# Rezoning Transportation Analysis

Petition Number: Zoning Petition #2021-011

General Location Identifier: Tax ID 10304127

Date	Description
02-25-21	First Review (WB)
03-25-21	Second Review (WB)
04-27-21	Third Review (WB)

ENGINEER: GTW
DRAWN BY: GTW
CHECKED BY: JB
PROJECT #: 019-011
SHEET
RZ-1
SHEET 1 OF 2

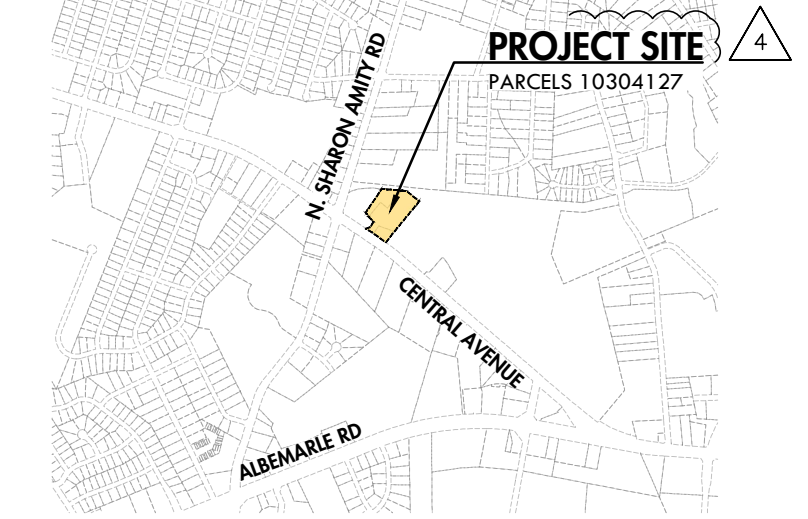
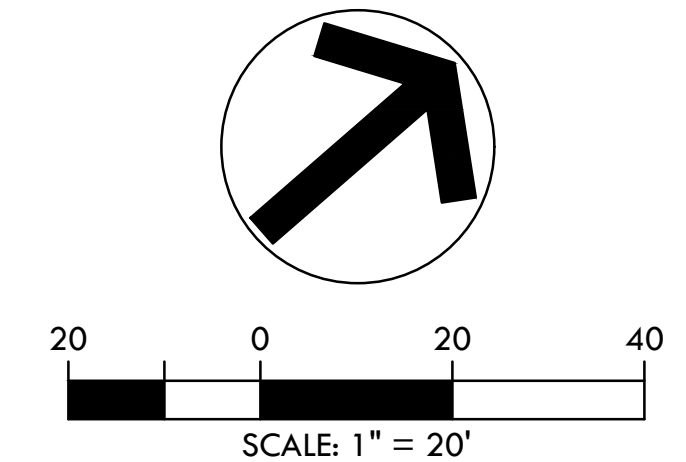
**Central Avenue:** Location of curb and gutter needs to be at 38 feet from the centerline to allow for a 4+ Avenue with an 8-foot buffered bike lane. **Rescinded (3/22/2021) based on meeting held on March 15<sup>th</sup>. The future curb and gutter will be located 38 feet from the centerline; however, CDOT will not require the relocation of the existing curb and gutter for this site plan, in order to tie into the CATS Street Car project and maintain a continuous typical section along Central Avenue.**

~~Label and dimension the existing curb and gutter from the road centerline on the site plan.~~

- ~~Revise site plan and conditional note(s) to commit to construct an 8-foot planting strip, and 8-foot sidewalk on Central Avenue per Chapter 19. The wider sidewalk also meets the Charlotte WALKS Policy. The site plan shall label and dimension both items from the back of curb and gutter. **Rescinded (3/22/2021)**~~
- ~~Site plan and conditional note(s) revisions are needed to commit to construct 8' buffered bicycle lanes by relocating the curb and gutter 38' from the center line to meet the City Charlotte BIKE Policy. **Rescinded (3/22/2021)**~~
- ~~Revise or Remove Conditional Note B.1, based on the results of the Traffic Impact Study, which may not allow vehicular circulation or maneuvering to occur in the setback area between Central Avenue and the buildings. **Rescinded (3/22/2021)**~~

- ~~Add a site plan note specifying dedication and fee simple conveyance of all rights-of-way to the City before the site's first building certificate of occupancy is issued. CDOT requests rights-of-way set at 2' behind back of sidewalk where feasible.~~
